From:
Sent: 08 October 2026 10:38
To: Laura Yeadon
Cc: DC Admin
Subject: Planning application number 2026/62/92432/W - Letter of objection

Proposed Vehicular Access and
Highway Alterations

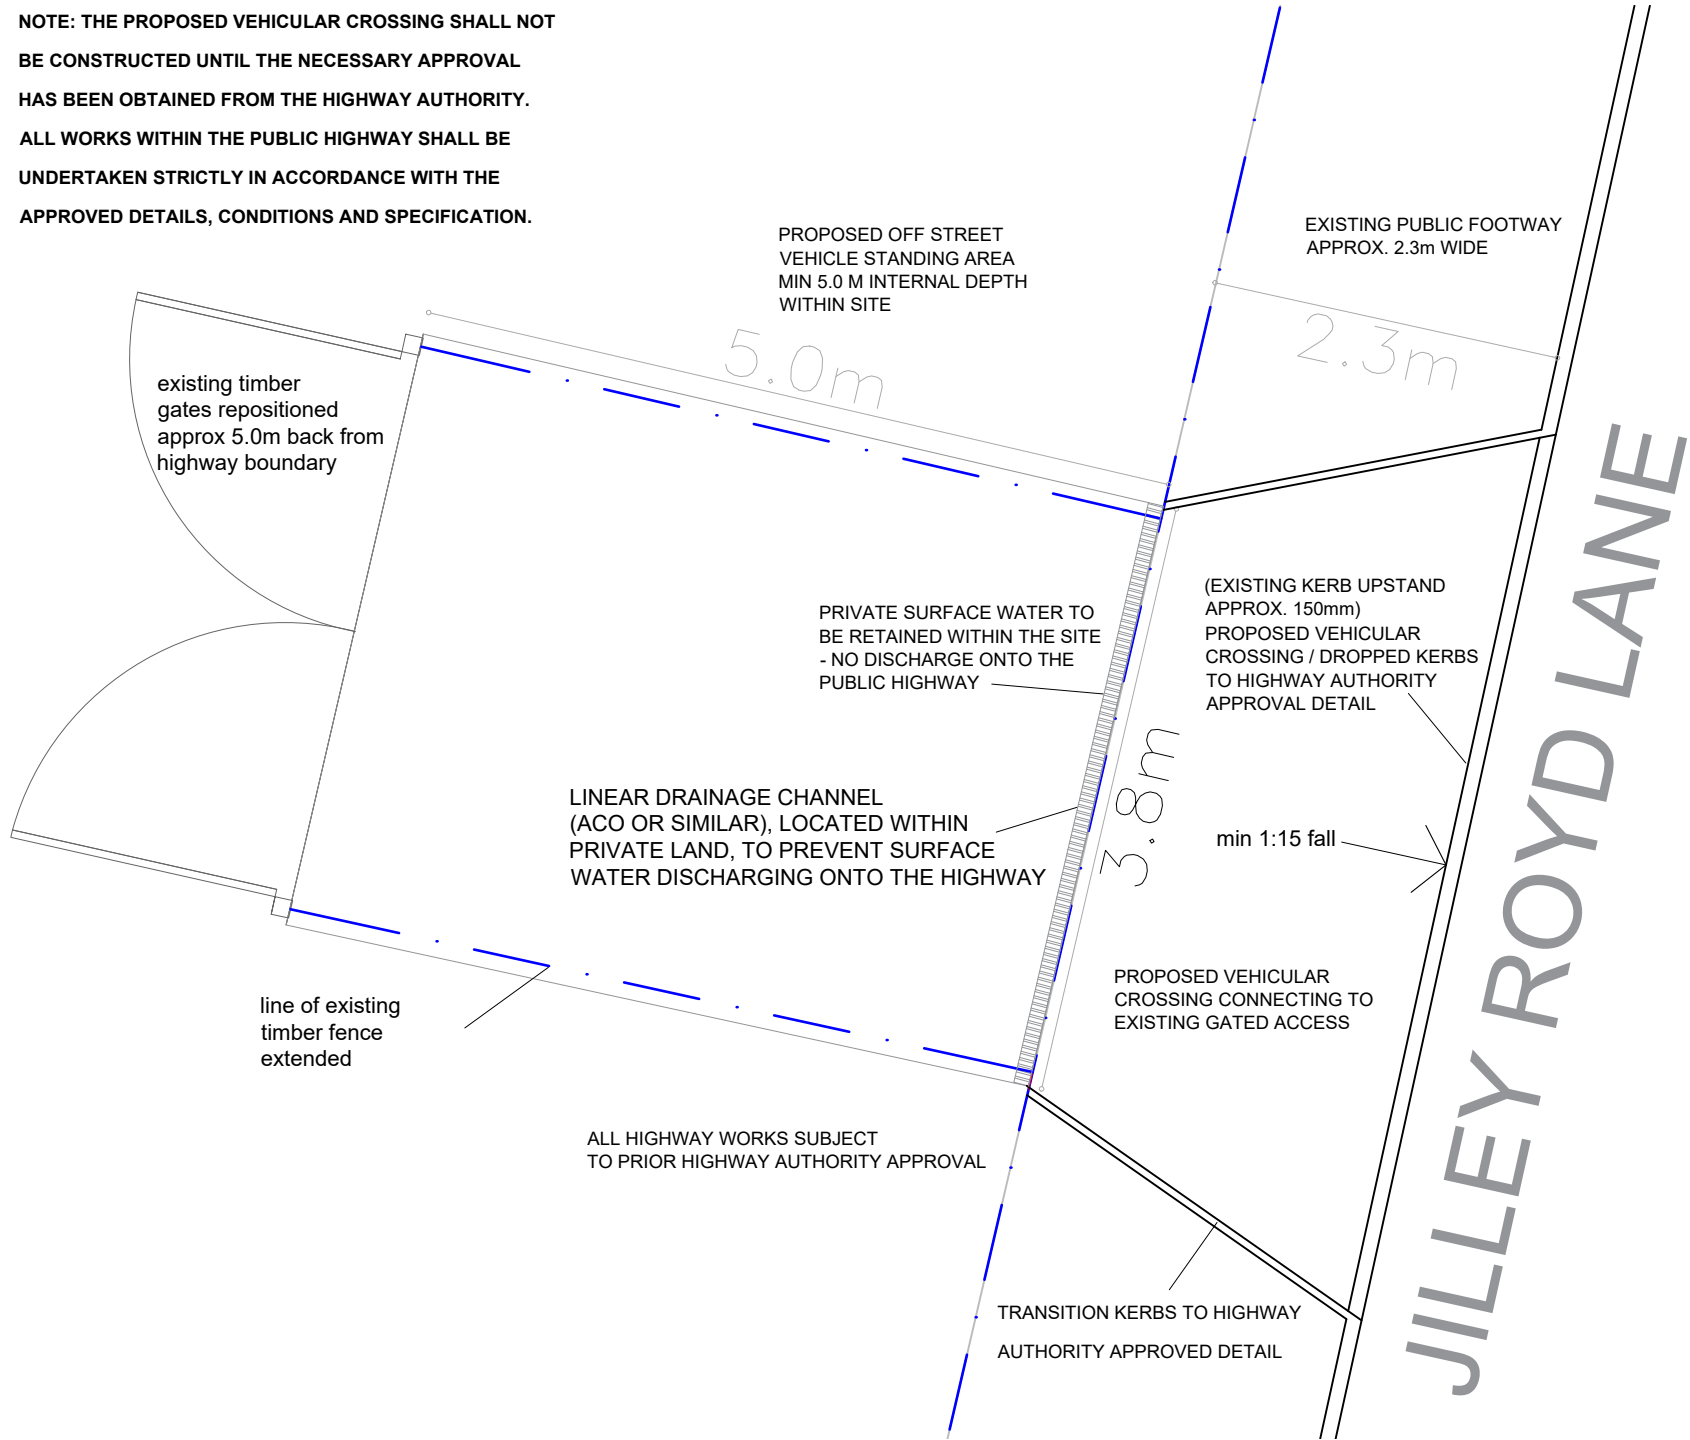
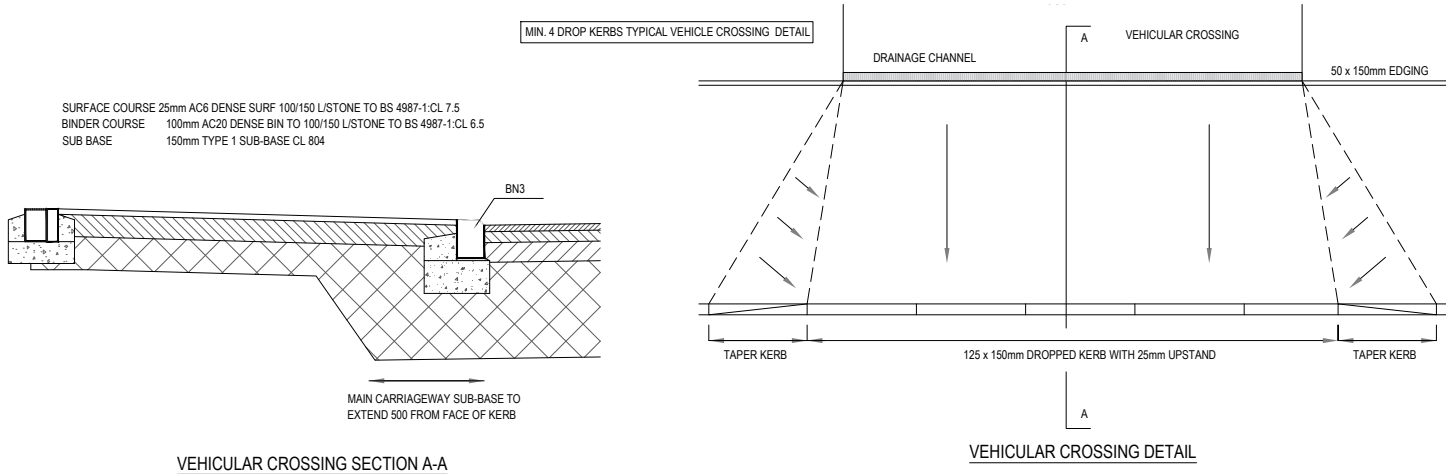
4. The application states the aim of the work applied for is to provide vehicle clearance and improve Highway safety. There are no issues with vehicle clearance and Highway safety as I have personally witnessed many large vehicle driving in and out of the protected woodland area over the last 2 years without any concerns for the safety of drivers or pedestrians. This also shows that there are no issues with vehicles accessing the woodland plot without a dropped kerb; i.e. a dropped kerb is not required for access. I have video evidence of these vehicles delivering builders waste and flagstones to the protected woodland; unfortunately the videos are too large to email, however the case officer can view them on my phone should they so desire. I would question the need for vehicle access to the protected woodland. What woodland management is proposed that requires this access, including a dropped kerb?

5. The current application is also asking permission to move the fence and the existing gates. Moving the gates and fence will directly impact the root protection areas of at least 2 trees, and could result in causing irreparable damage to these trees and most probably lead to their death. I am aware alongside many other neighbours that the reason the applicant, [redacted] wants to move the gates back 5 metres from the public footpath is to create some parking places. This is not just mine or the neighbours' opinion, it is because the applicant has stated as much to the local residents. His house, 46 The Fairway, has 3 parking places on its drive, however the applicant refuses to park his car on the drive as 2 of the cars have to be parked one behind the other and the cars may need to be moved to allow another member of the family to get their car out. Moving the gates back 5 metres would not allow any vehicle longer than a family car to be parked there without encroaching onto the public footpath. The area of 3.8 metres by 5 metres created by this proposal would comfortably allow at least two domestic/family cars to be parked in this area. The relocated gates and the lowered kerb would allow other vehicles i.e. cars to access the protected woodland in order for that area to be used to park domestic and/or vehicles for sale (which would lead to commercial activity on the site). Both the 2016 and 2017 applications included the creation of 3 parking places in the protected woodland plot. There is record of the applicant trying to use the woodland for commercial vehicles; a neighbour sent in photographic evidence of a vehicle and low loader being parked in the woodland plot every day. Unfortunately, I cannot remember the exact year this occurred, it may have been 2021; I do know that [redacted] was spoken to by an employee of the council so there should be a record of this complaint, most likely it was reported to the Trees Section.

Site Location Plan

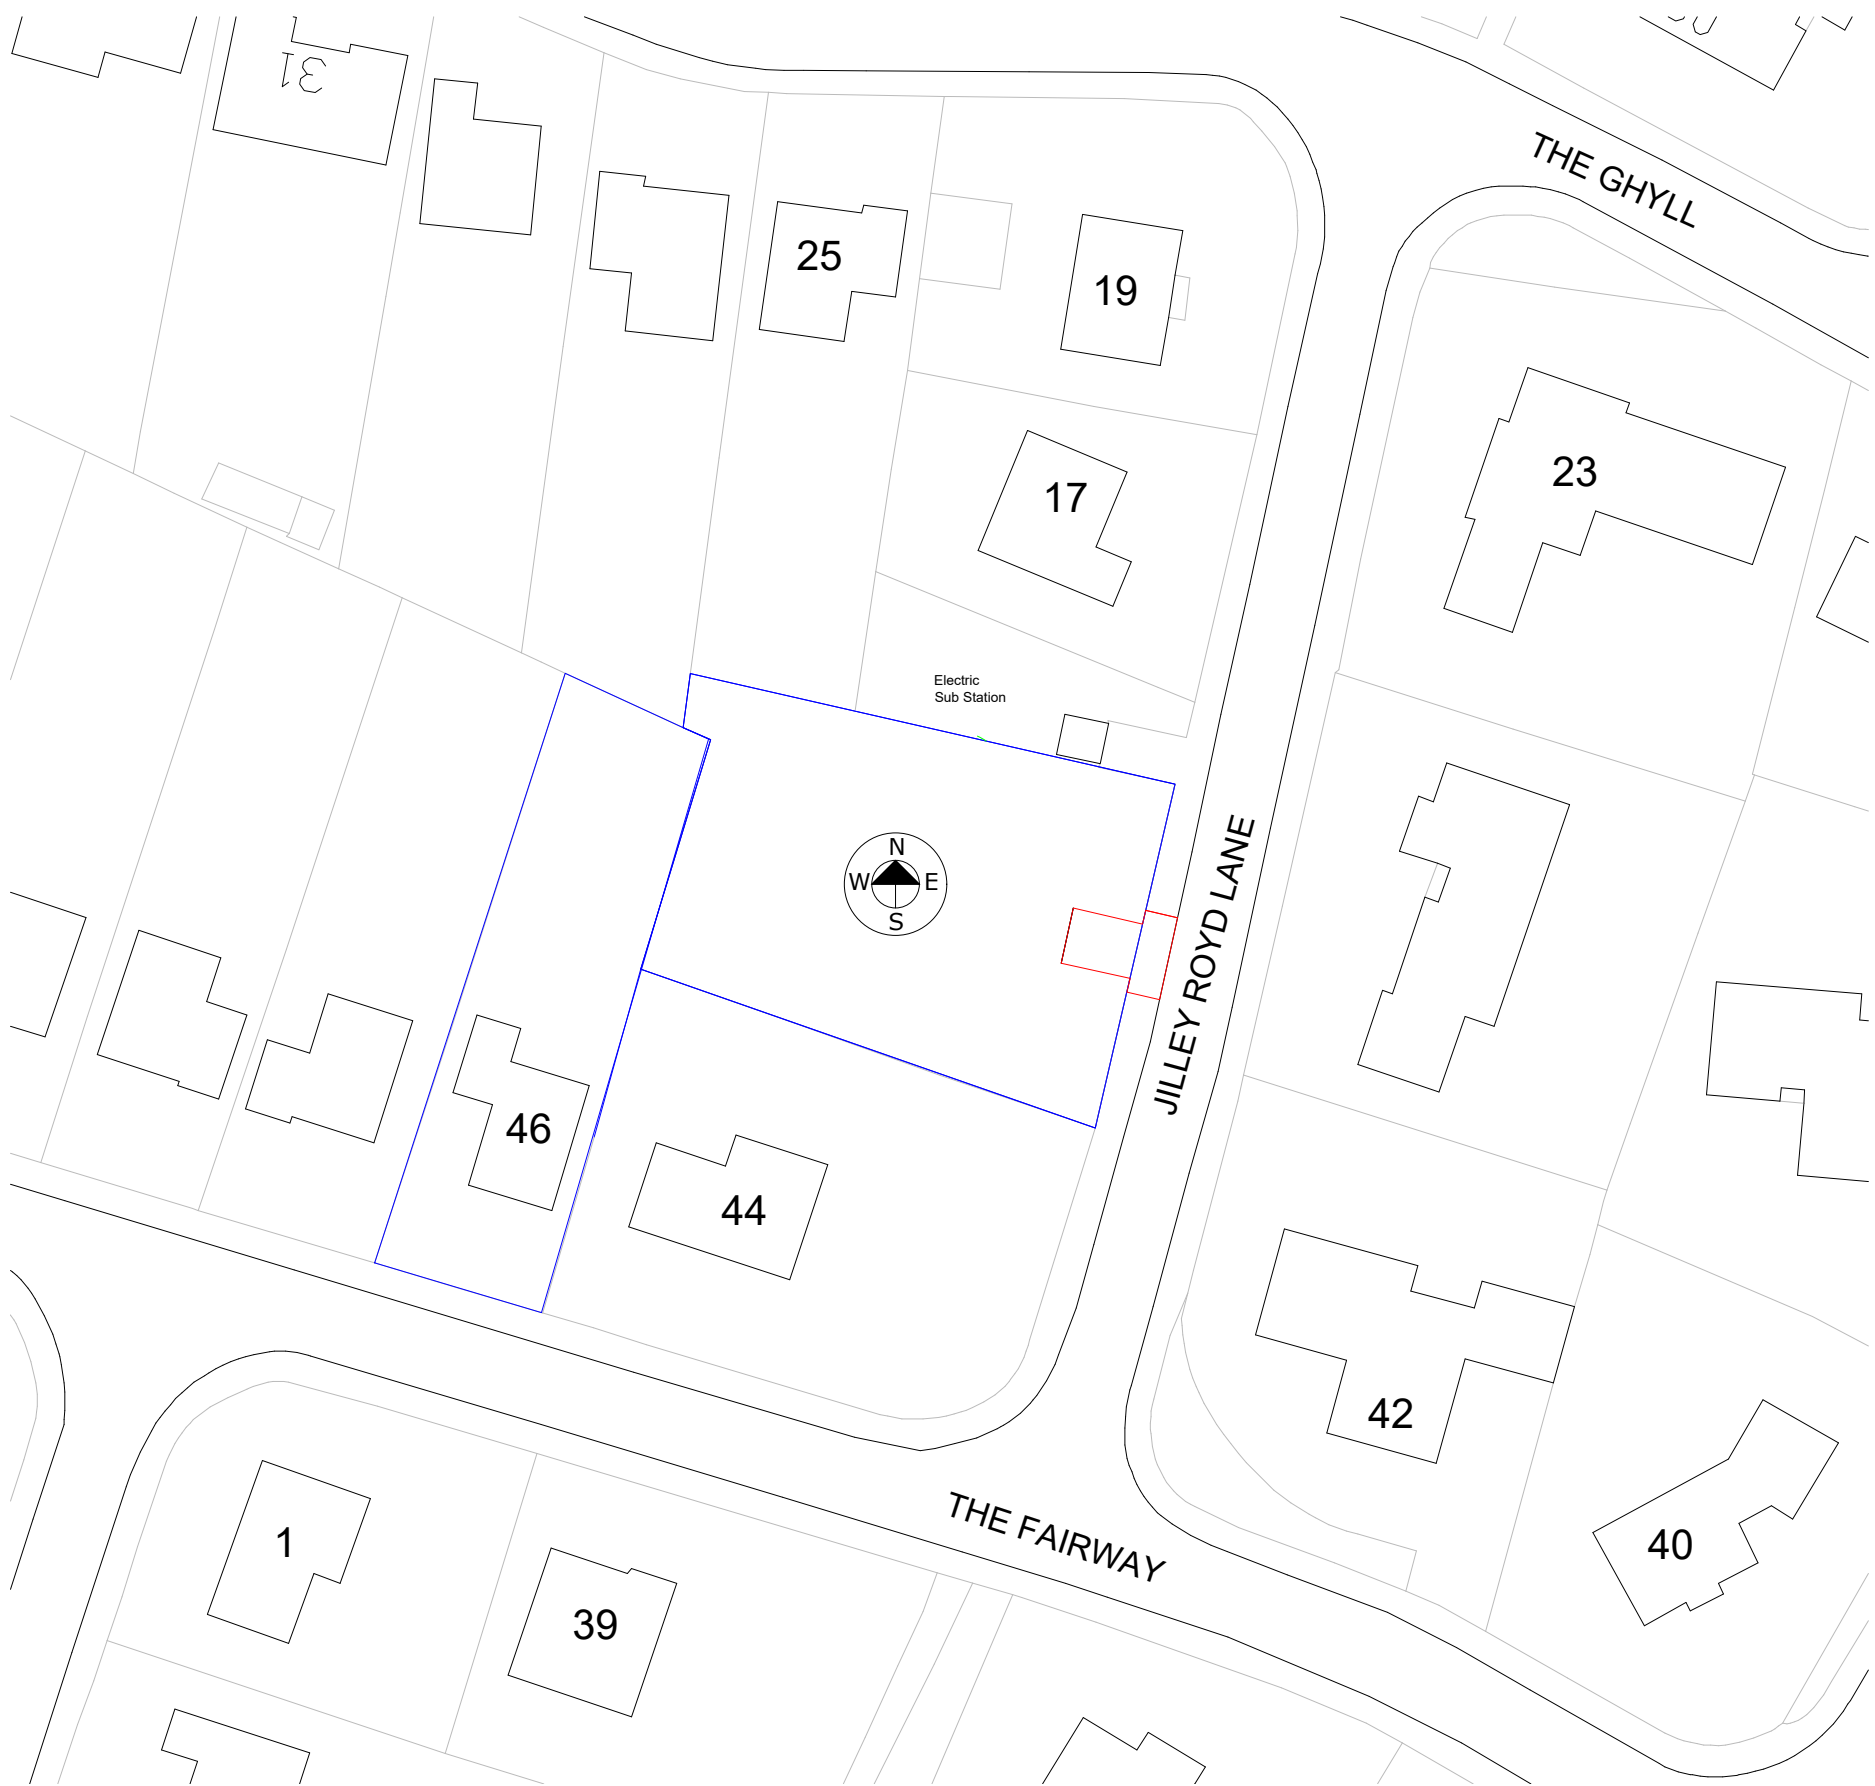
Prior to stating my reasons for objecting to this planning application, I would like to bring to your attention that the plans of the protected woodland plot submitted by the applicant, are incorrect. A number of the boundaries of the woodland plot are incorrect; the correct boundaries are as shown in application number 2017/62/91286/W. I have checked this information with the Land Registry online as the Land Registry allows individuals to access this information on payment of a fee. There are also some discrepancies in the position/outline of the protected trees in the woodland plot.
